A303 Amesbury to Berwick Down

8.6 Statement of Common Ground – Natural England

STATEMENT OF COMMON GROUND – Natural England

Version	Date	Status of Version
Rev 0	03.05.2019	Deadline 2 Issue

- LEGEND**
- PUBLIC RIGHT OF WAY (PROW)
 - PRIVATE MEANS OF ACCESS (PMA)
 - PROW AND PMA
 - ORDER LIMITS
 - PERMANENT FENCELINE
 - MAMMAL TUNNEL WITH ASSOCIATED FENCING

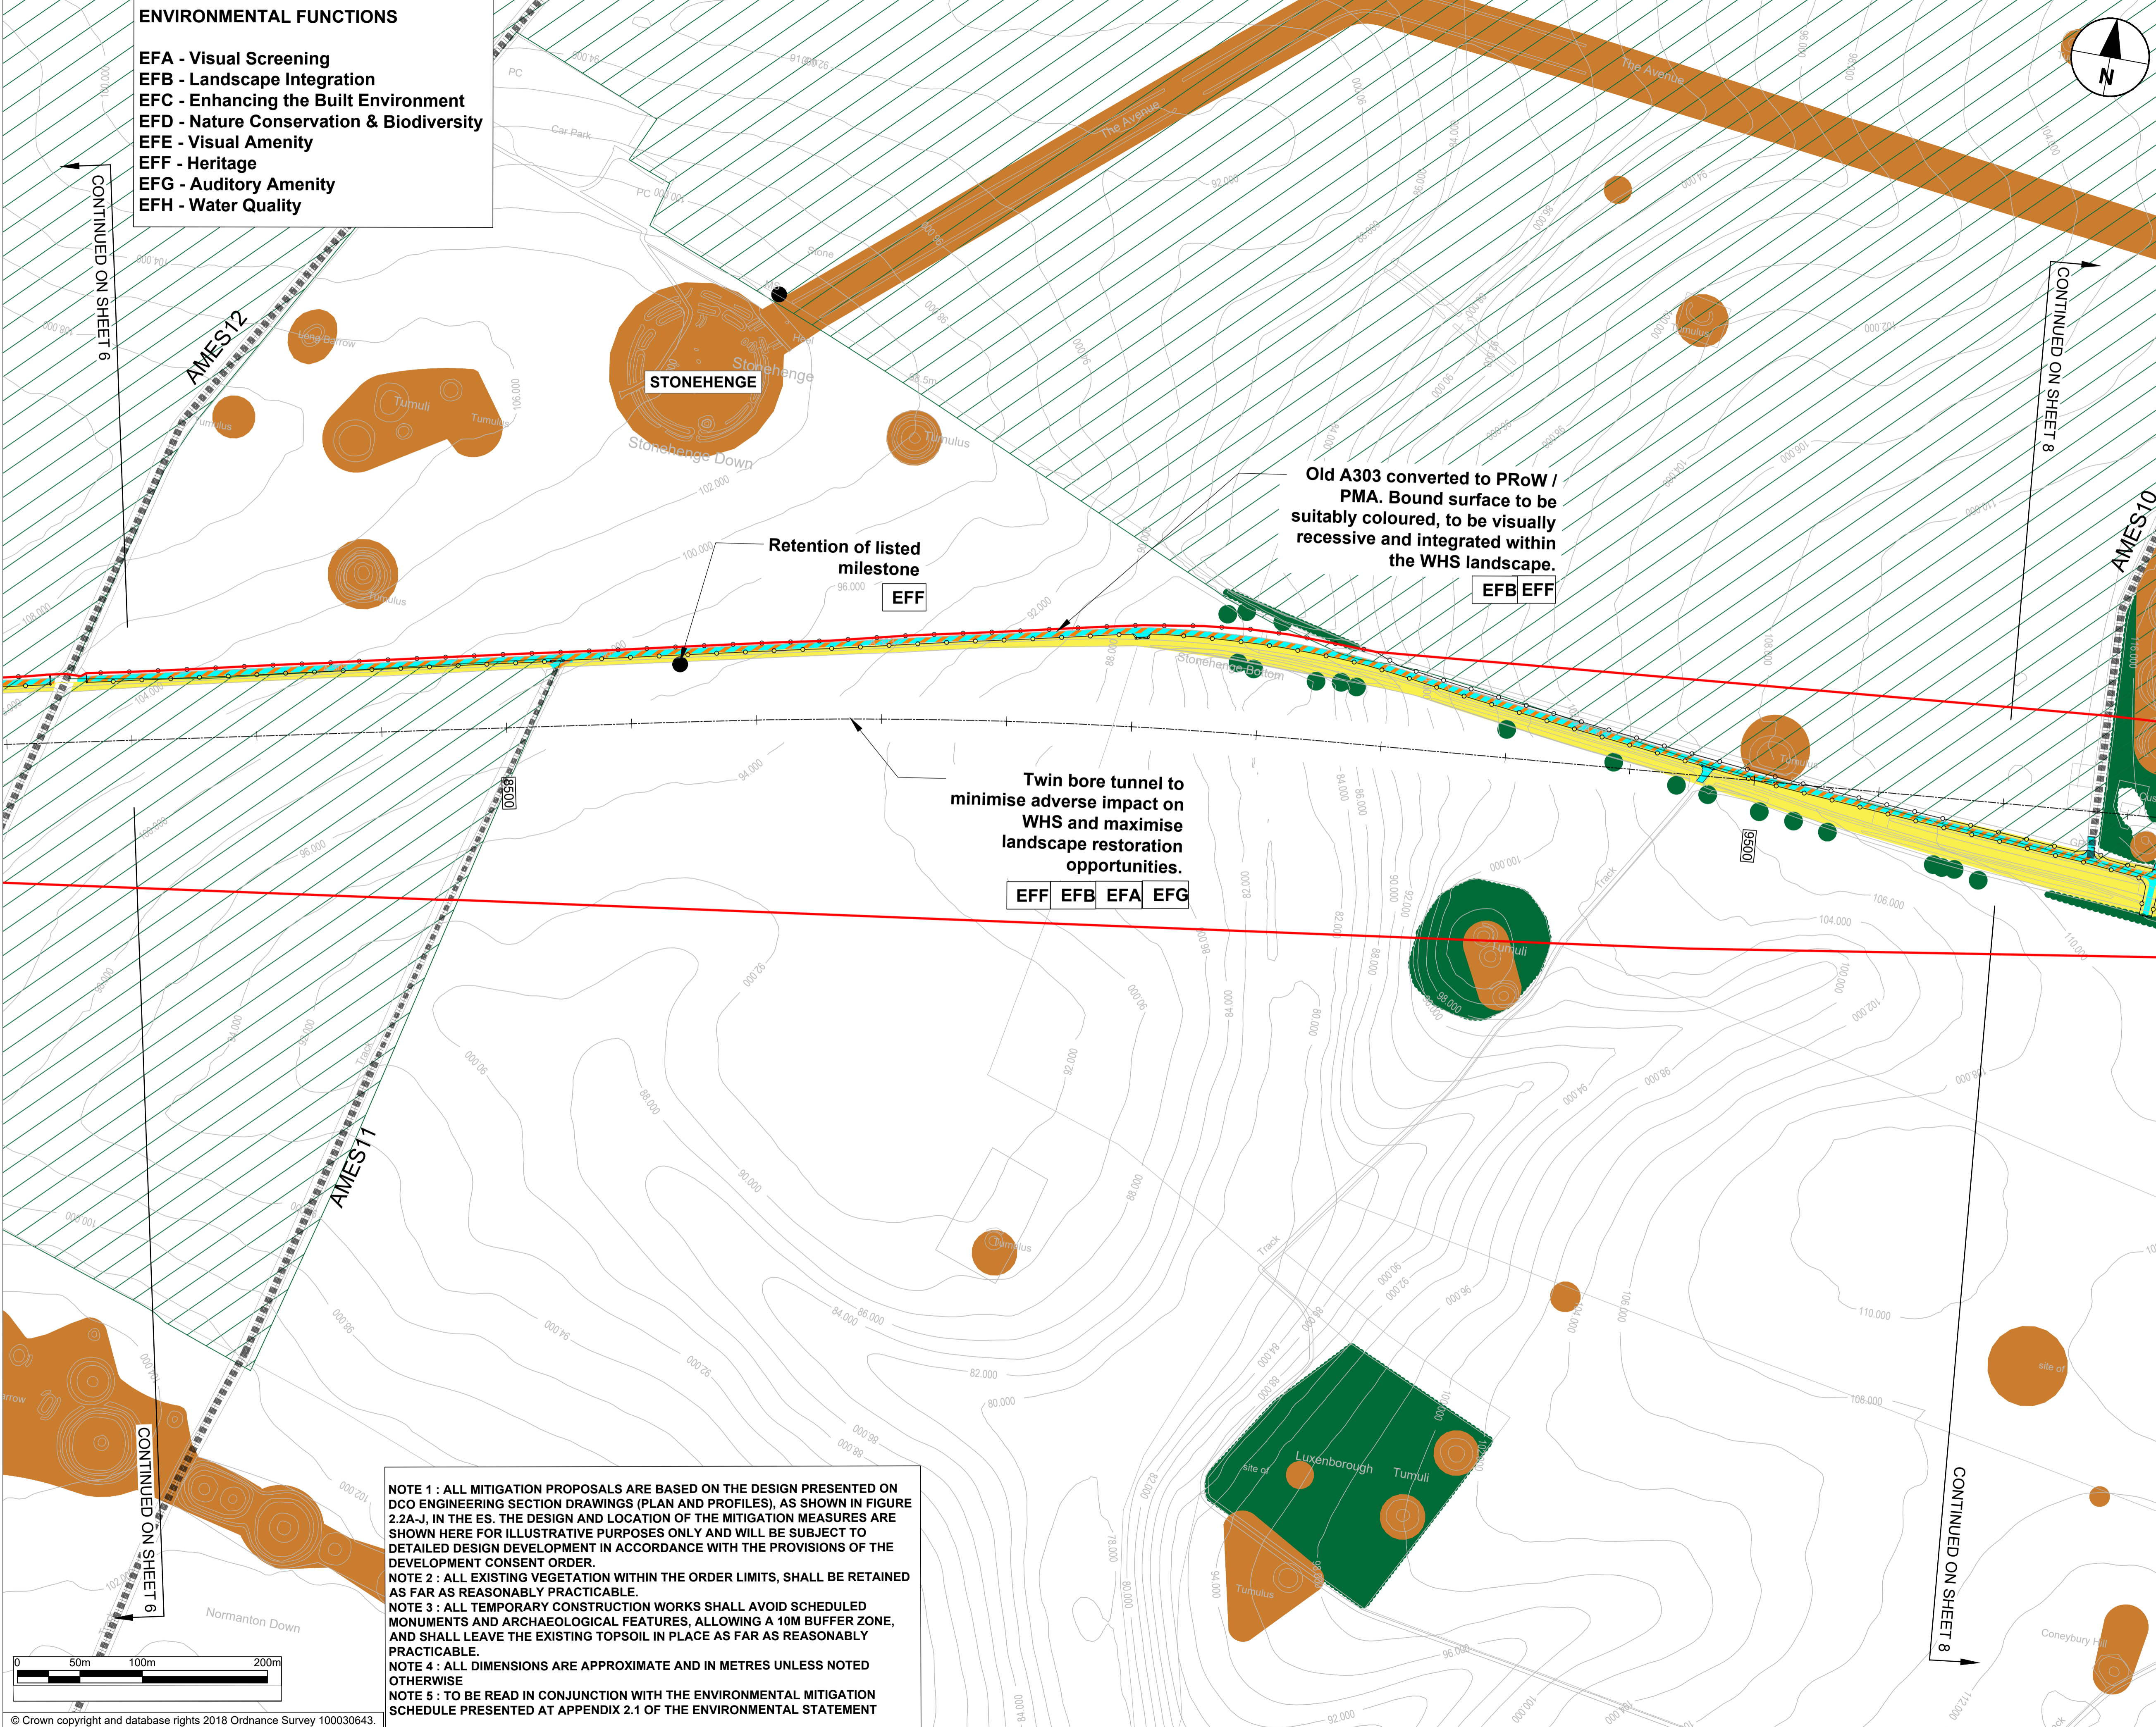
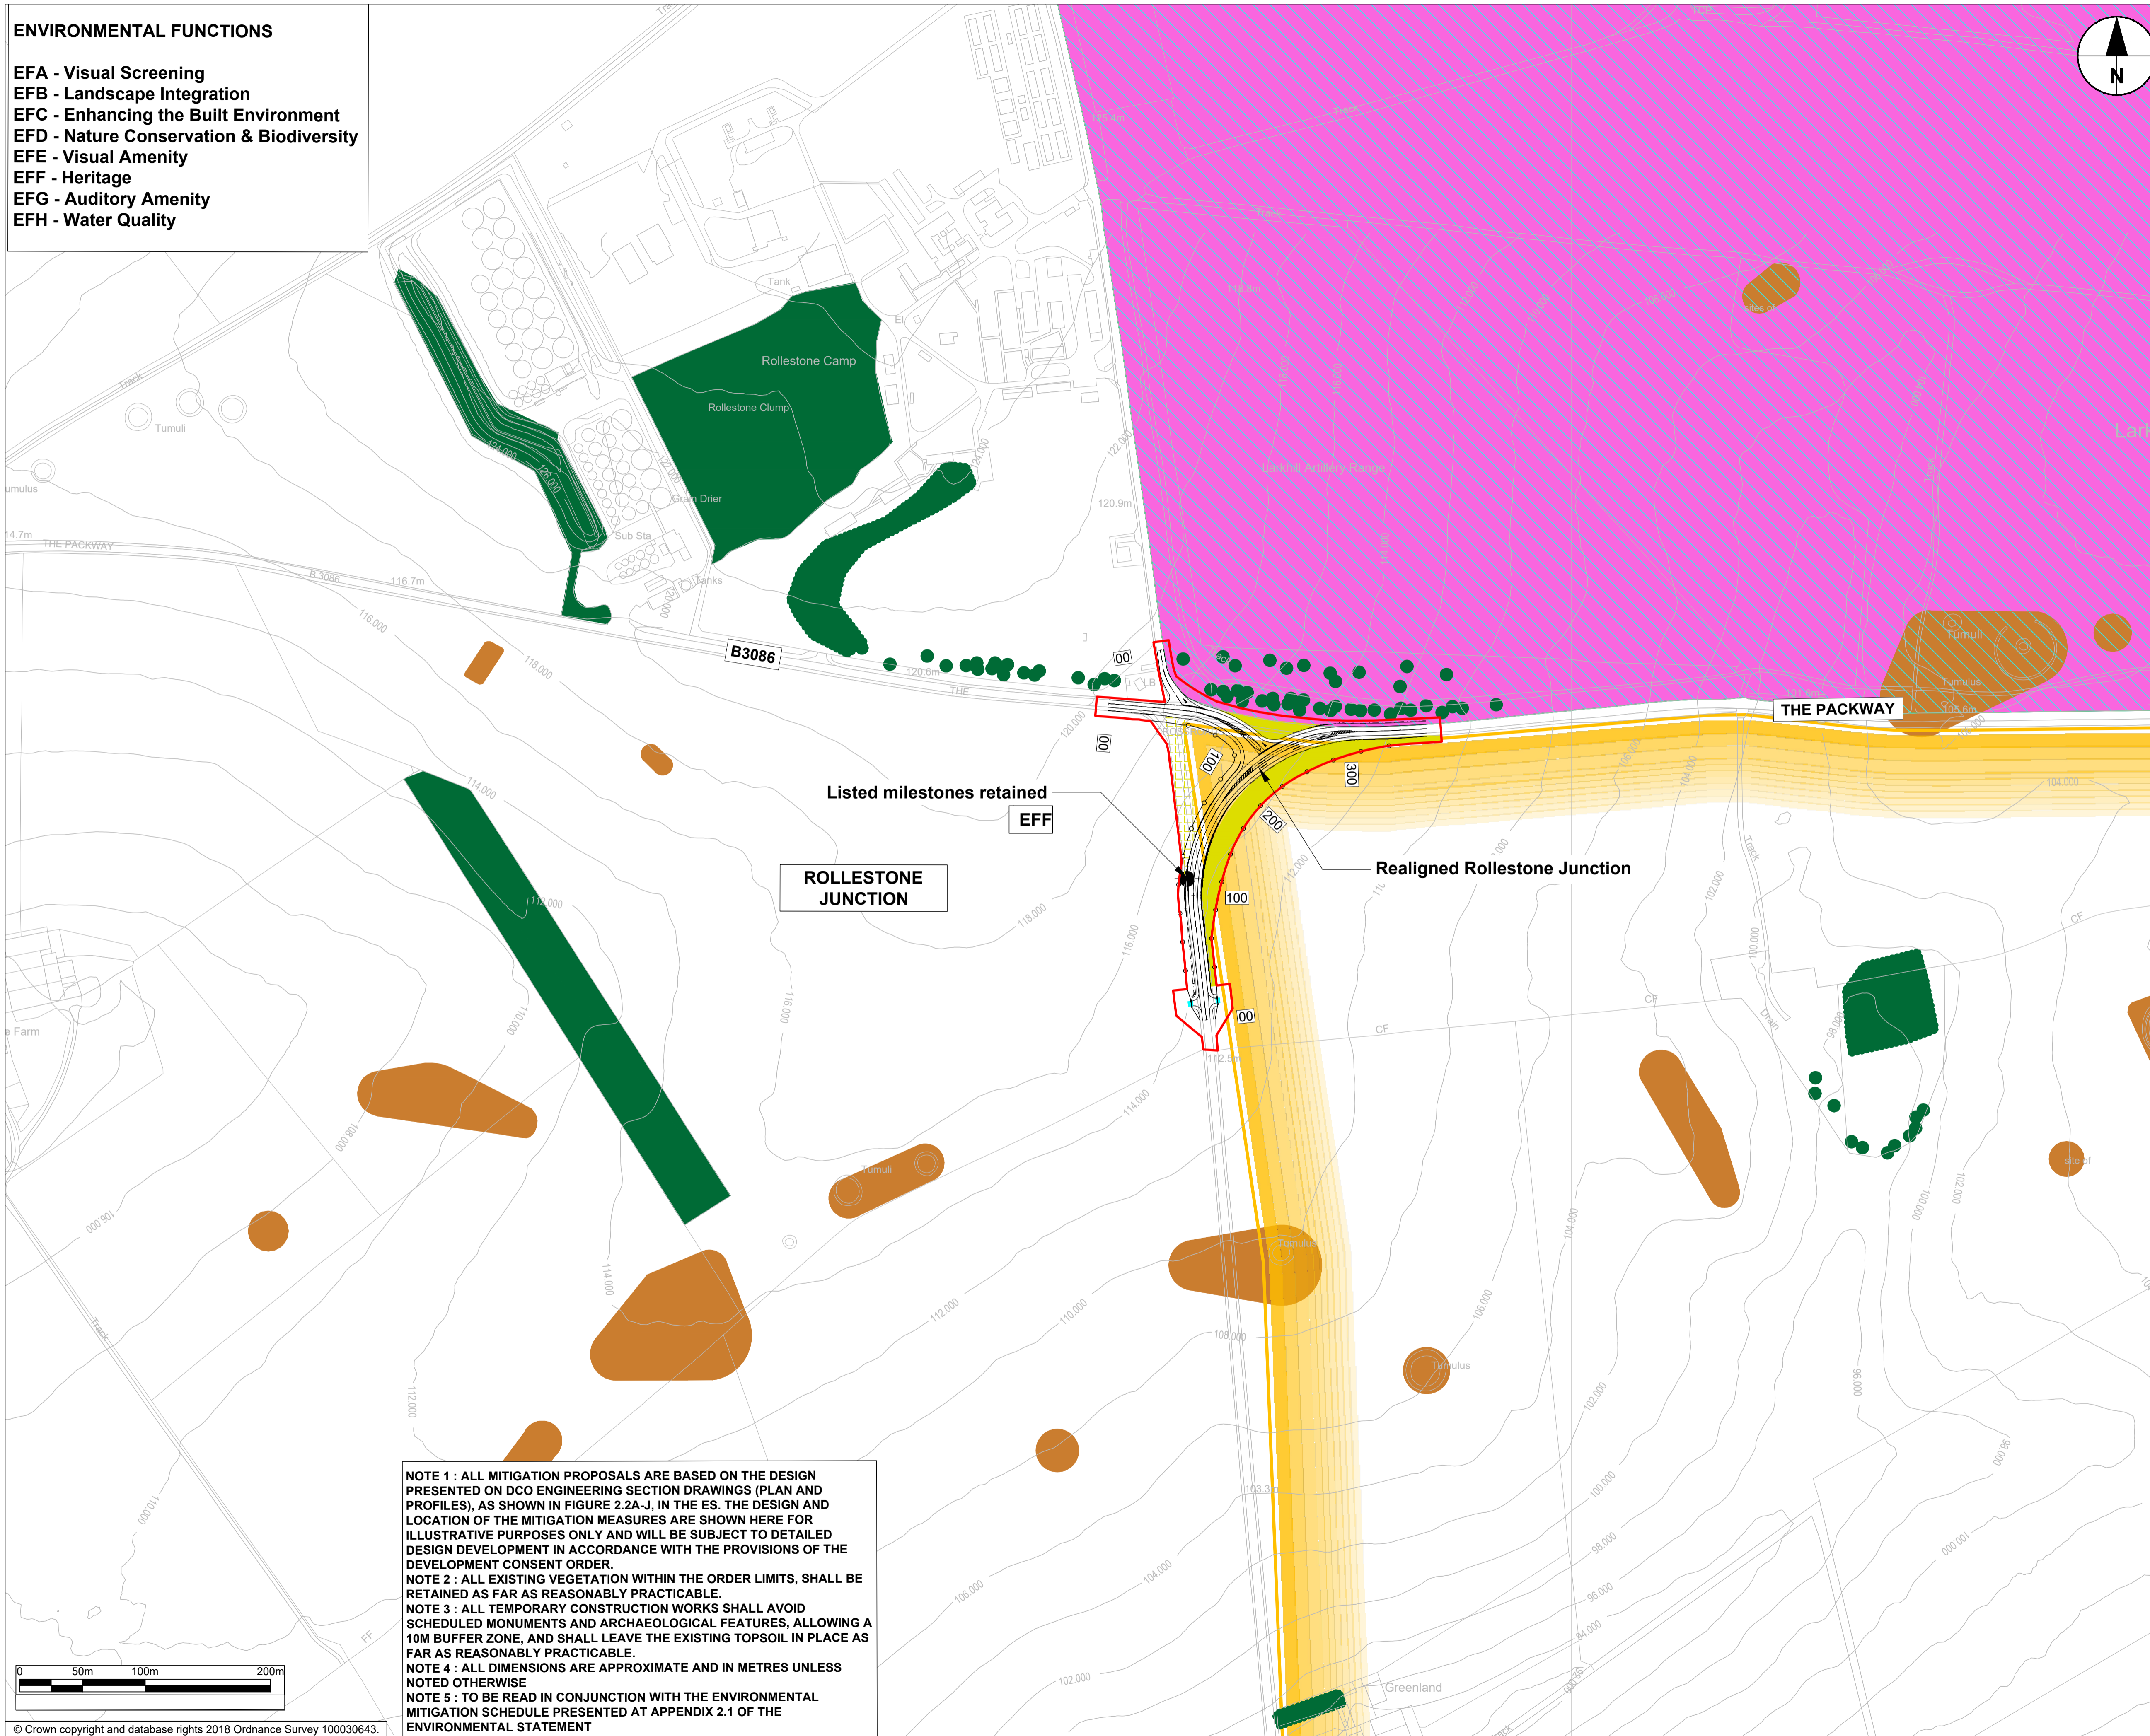
4.2	Environmental Statement Chapter 8 Biodiversity [APP-046]	Paragraph 8.9.71	Embedded mitigation Fencing	<p>We advise that the public right of way and Private Means of Access (PMA) route west of Green Bridge One is separated from the species rich chalk grassland to the north. Lack of fencing is likely to cause significant difficulties</p>	<p>Specific stock-proof fencing has been included within discrete areas and in locations associated with mitigation fencing.</p> <p>In the areas where chalk grassland is to be managed by grazing,</p>	Under Discussion

<p>due to conflict between dogs (and their owners) and stock management. Having the right establishment and management regimes for both these areas will be critical. Natural England is continuing to advise Highways England on the OLEMP.</p>	<p>appropriate access for stock, fencing and stock watering facilities would be provided, as described in ES Chapter 8, Biodiversity [APP-046], 8.9.71.</p>
